Application by EPL 001 Ltd for Stonestreet Green Solar

The Examining Authority's written questions and requests for information (ExQ1) Issued on 10 January 2025

Written Representation prepared by Aldington & Bonnington Parish Council, 31 January 2025

- Key:
- Order limits
 - Vegetation To Be Removed
 - (T) Individual tree to be removed
 - (G) Tree group to be removed
 - (H) Hedgerow to be removed
 - 1-29 Field Number

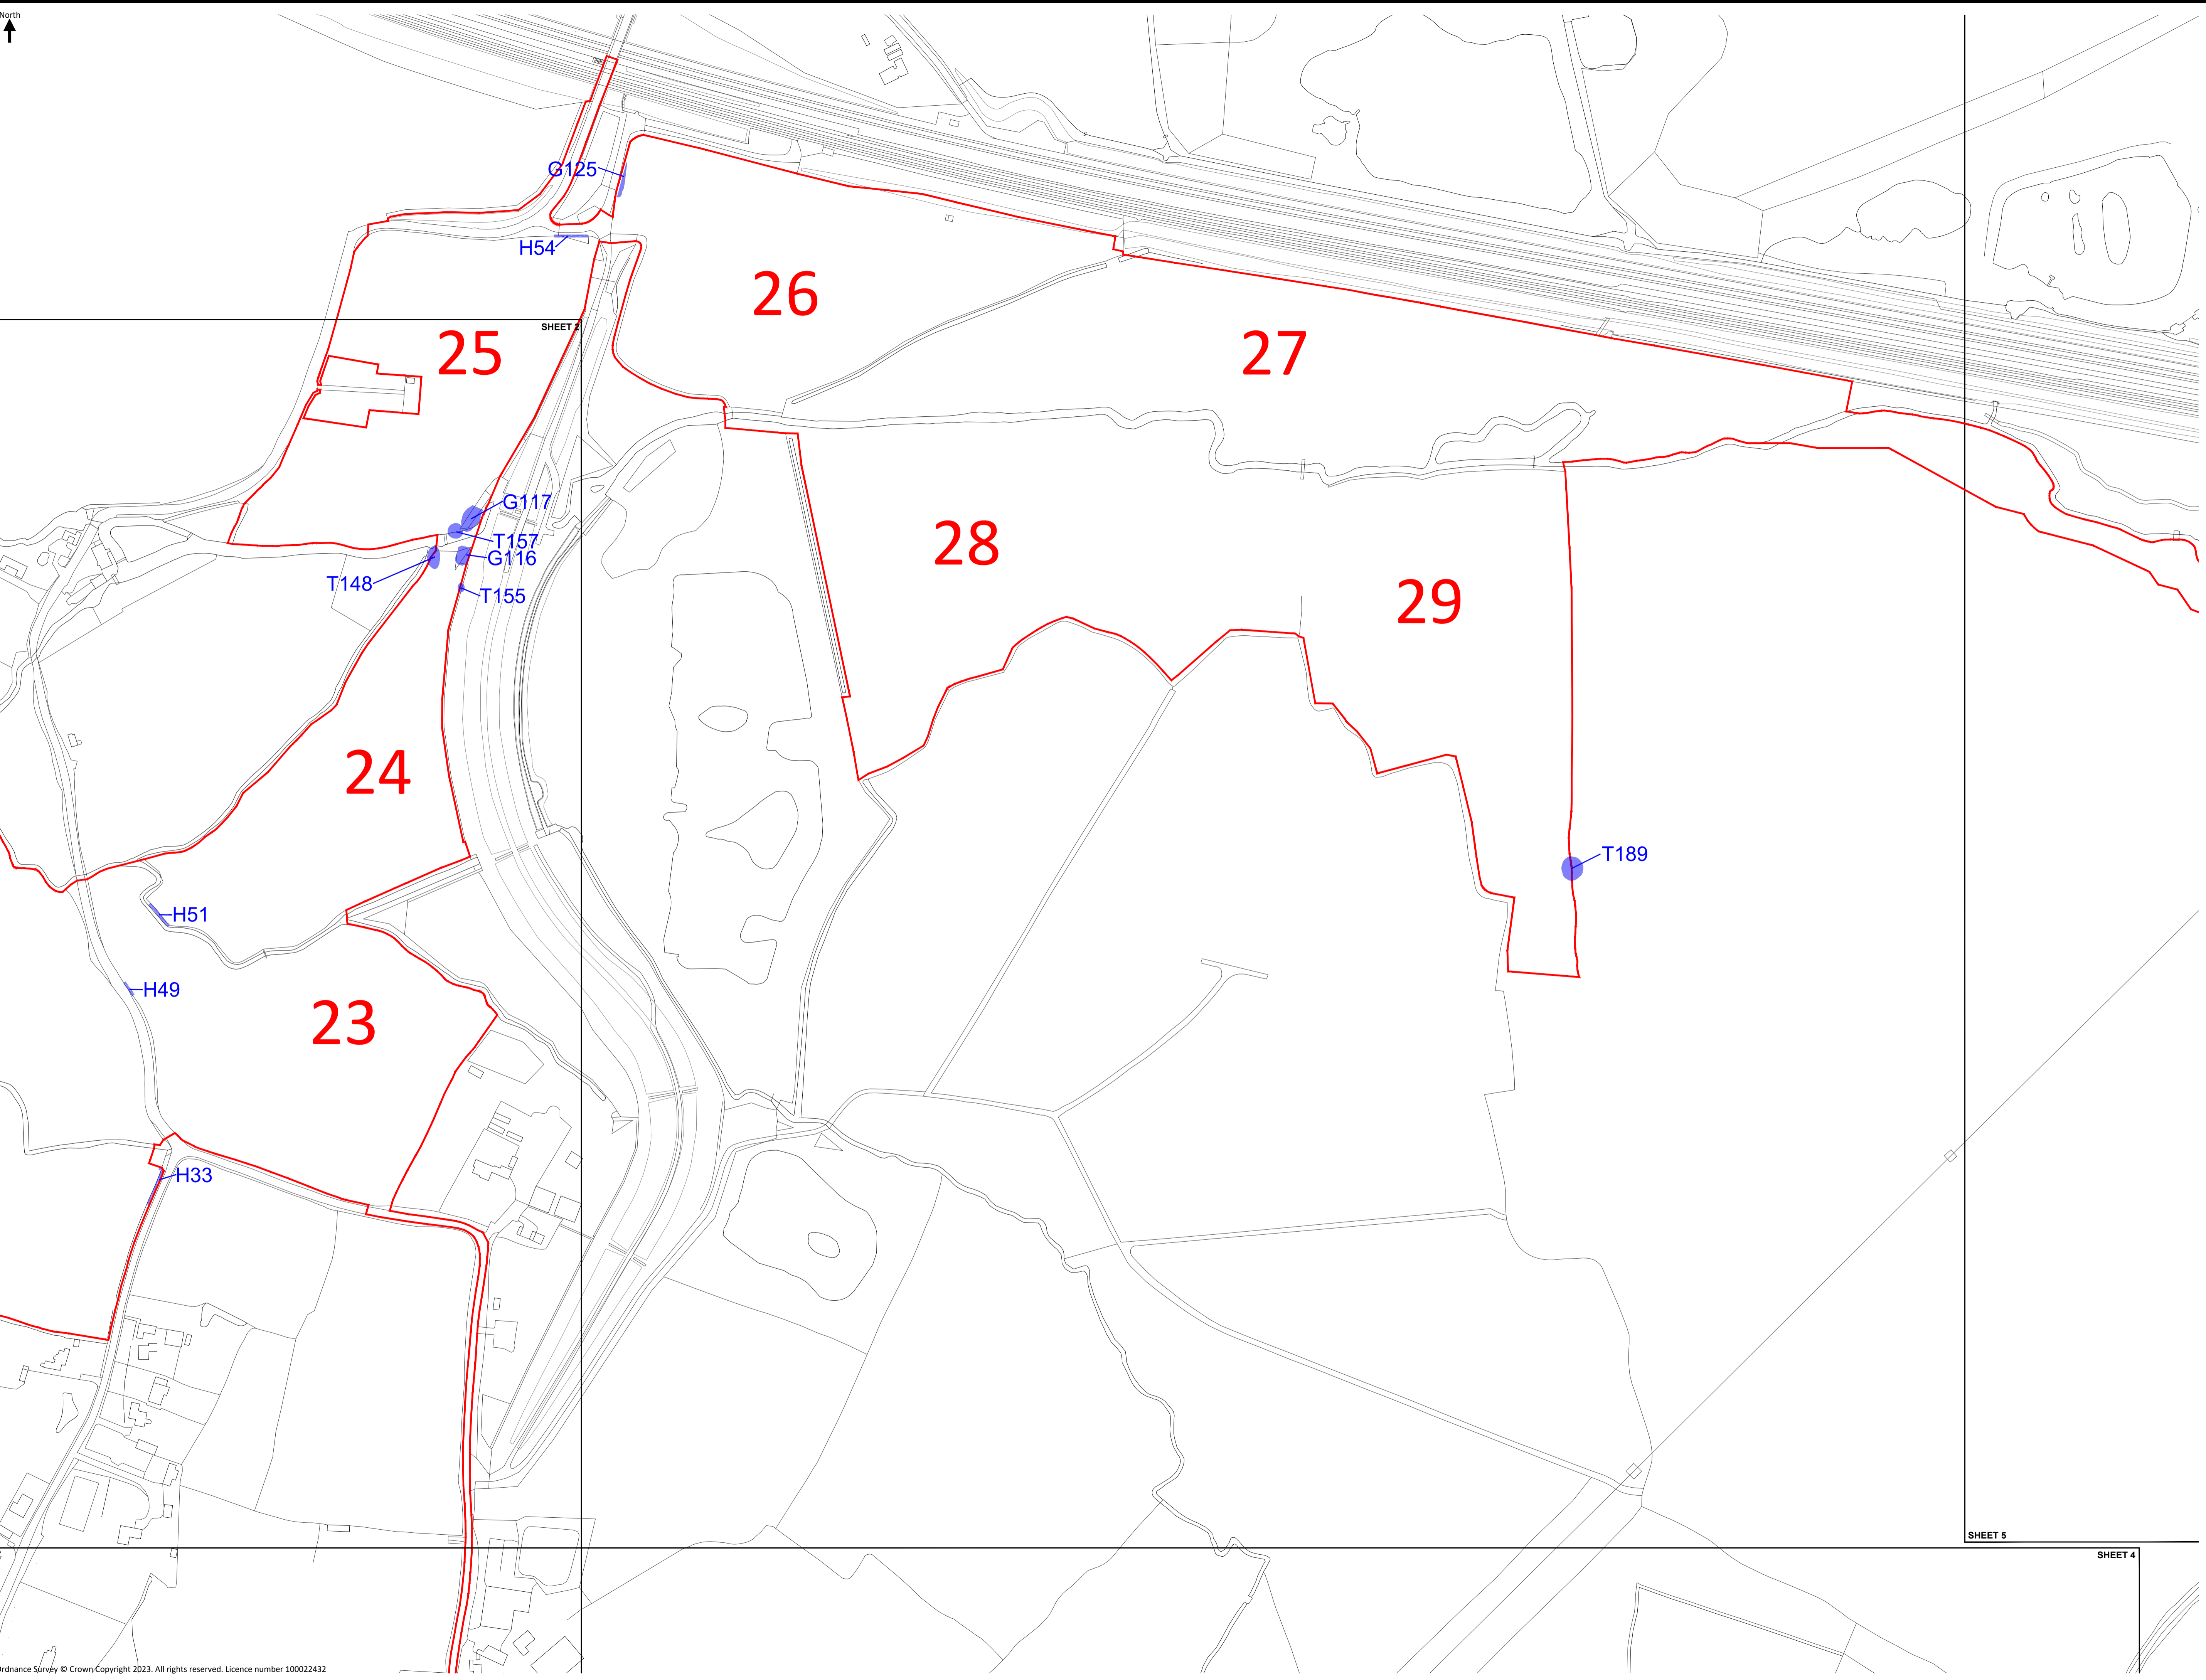
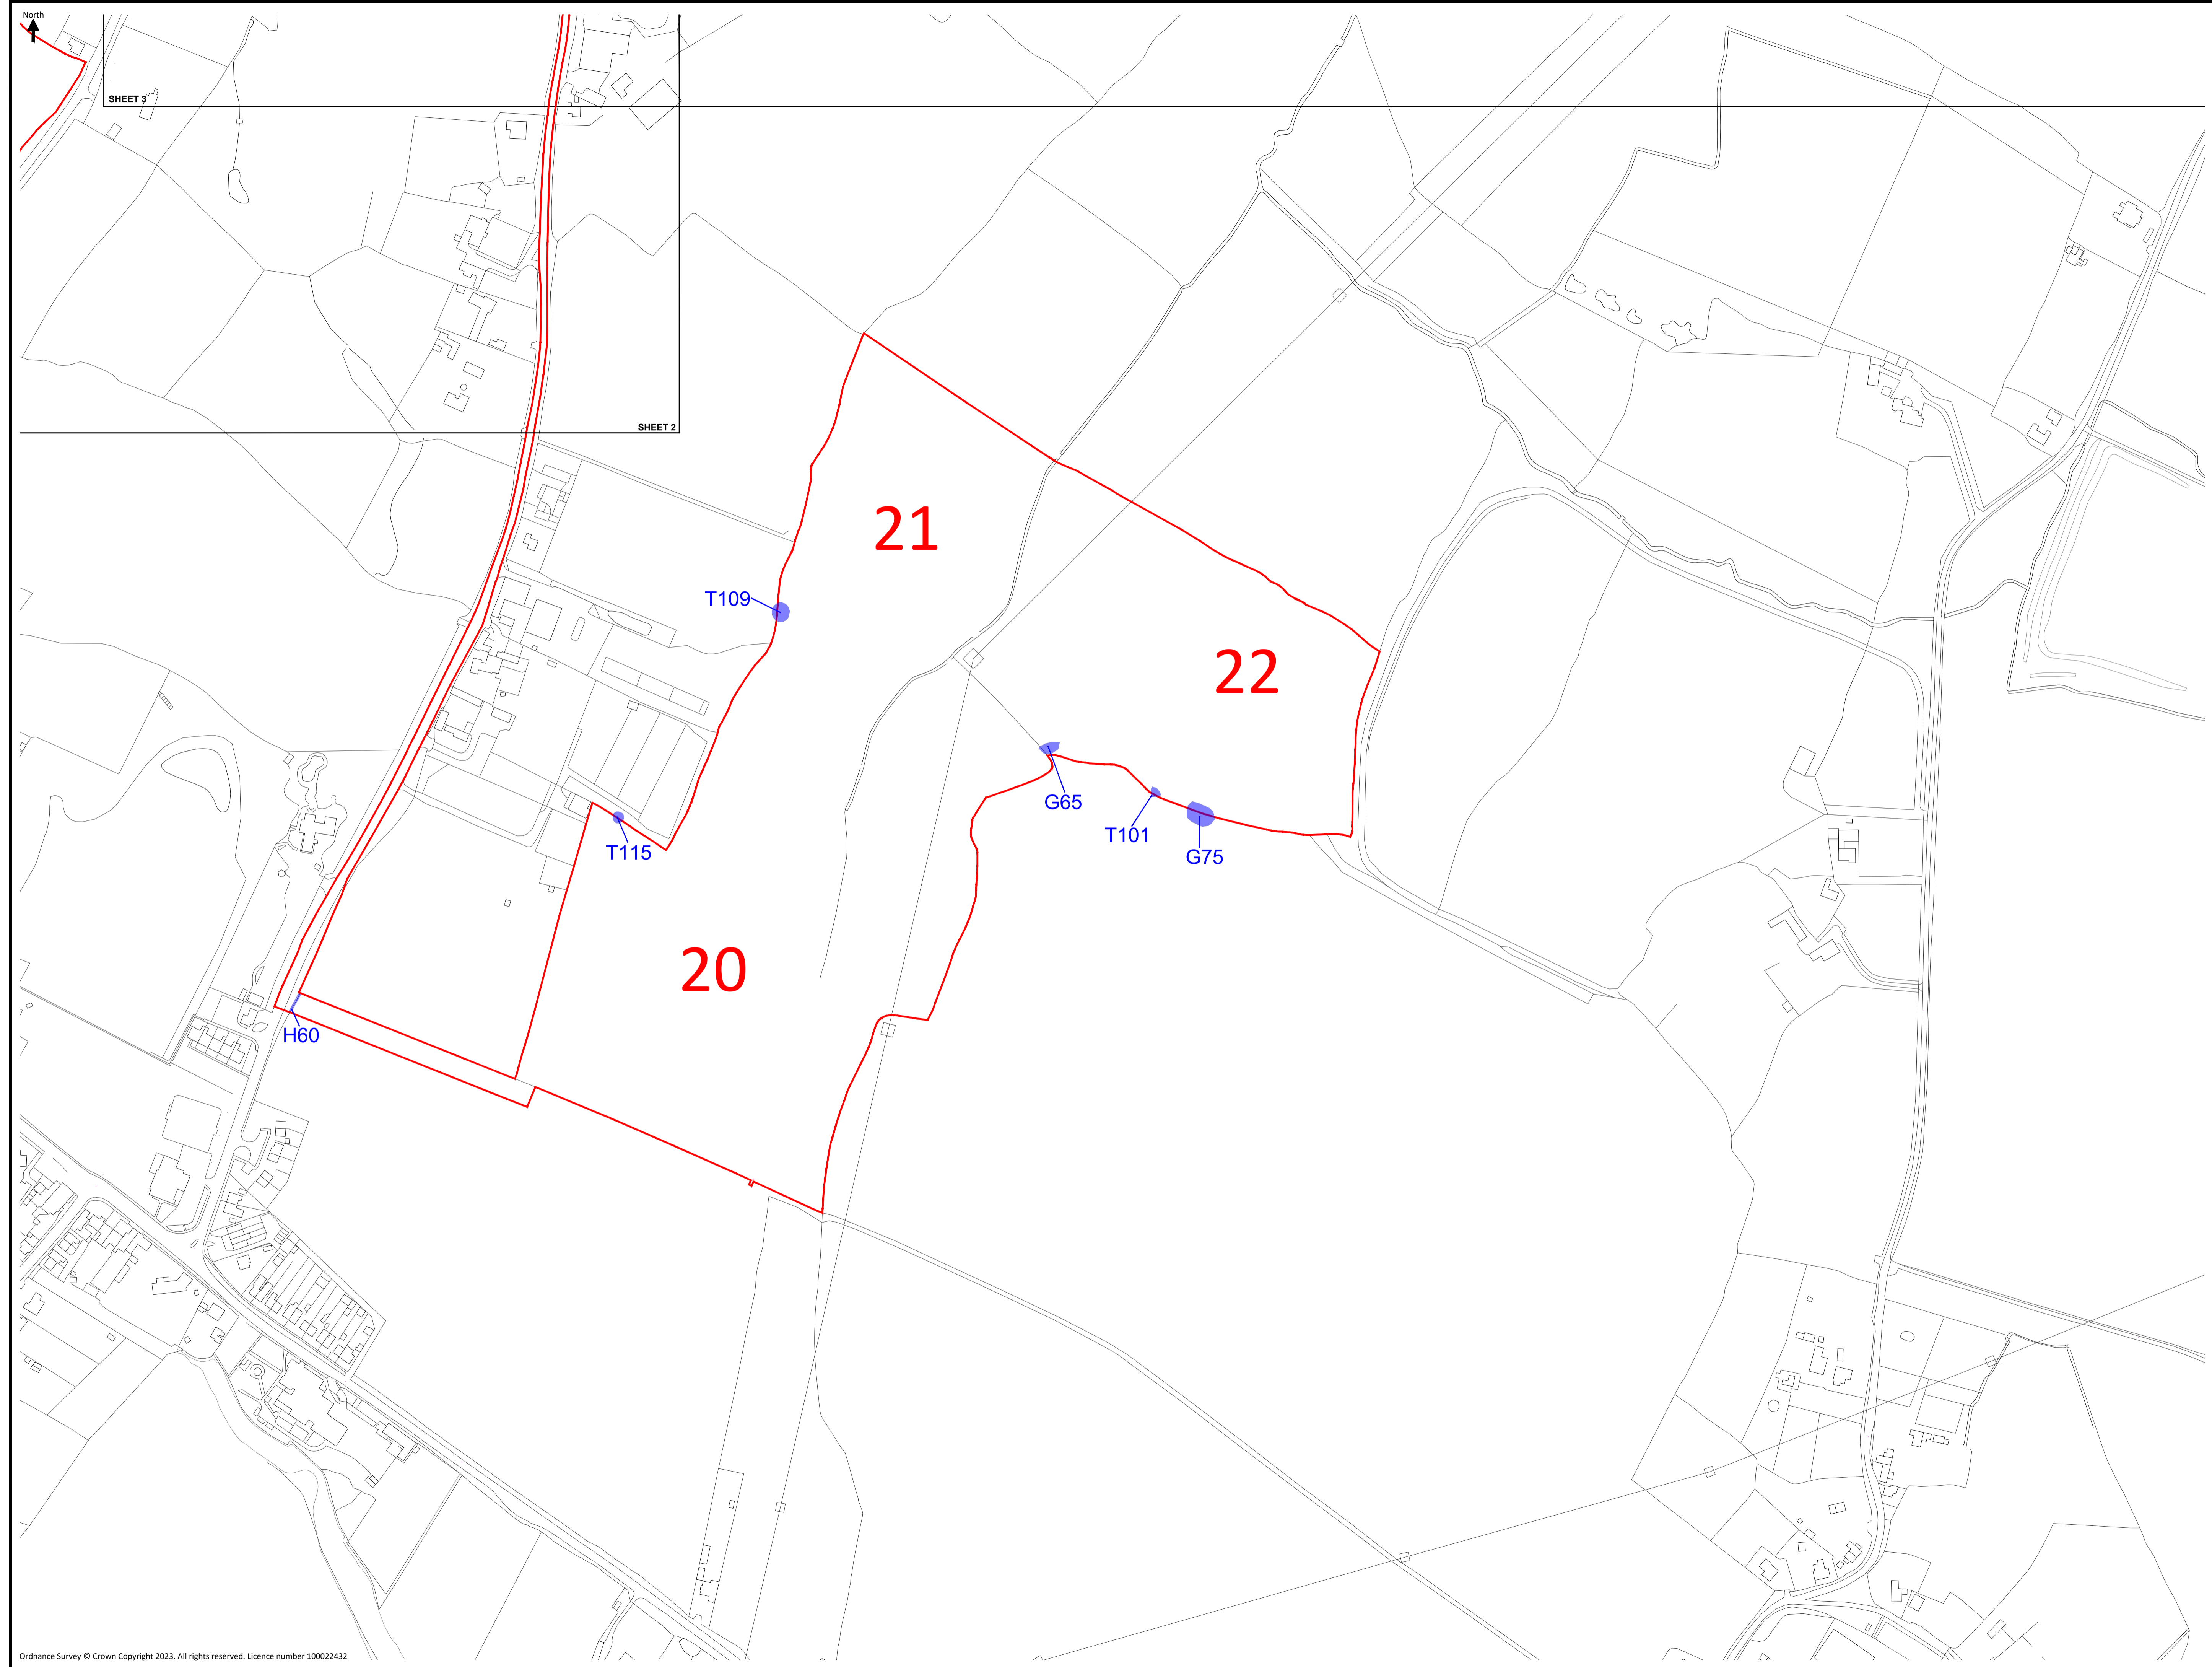
We strongly believe that this prior consent by the local planning authority should be required for the removal of trees and/or hedgerows. The Aldington and Bonnington Neighbourhood Plan (ABNP) is a legally binding document that forms part of the Local Development Plan, sitting alongside Ashford Borough Council's Local Plan. It represents the views of the community and should inform planning matters. Policy AB1 maps the green and blue infrastructure across the parish, with specific features identified as being important within this network. Some of these features fall within the proposed site footprint. As per Policy AB1, important species should be protected. We would request that any trees or hedgerows removed are replaced. We consider this appropriate and achievable. This would also align to ABNP Policy AB12 (C), which supports the retention of roadside and pathside hedges, trees and verges.

Our response under Q4.0.4 is relevant here. As part of the work on the ABNP, a hedgerow survey was undertaken and ABPC would be keen to be involved in discussions about important hedgerows. As above, some of these features fall within the proposed site footprint. As per Policy AB1, important species should be protected. We would request that any trees or hedgerows removed are replaced. We consider this appropriate and achievable.

We welcome this question and our response under Q4.0.4 is relevant here. There are a number of Tree Preservation Orders on trees in or adjacent to the site, including along some of the roads identified as main routes into/out of the site (Calleywell Lane and Station Road). In their response to ABPC's Deadline 1 submission, the Applicant states that "any damage resulting solely from construction activities will be rectified at the cost of the Applicant. Additionally, highway verges will be restored to their previous condition should temporary surfacing be laid across them to aid the passage of construction traffic." (Application Document Ref: 8.8, p. 151). No reference is made here to the removal of trees, including those with TPOs, which cannot simply be replaced.
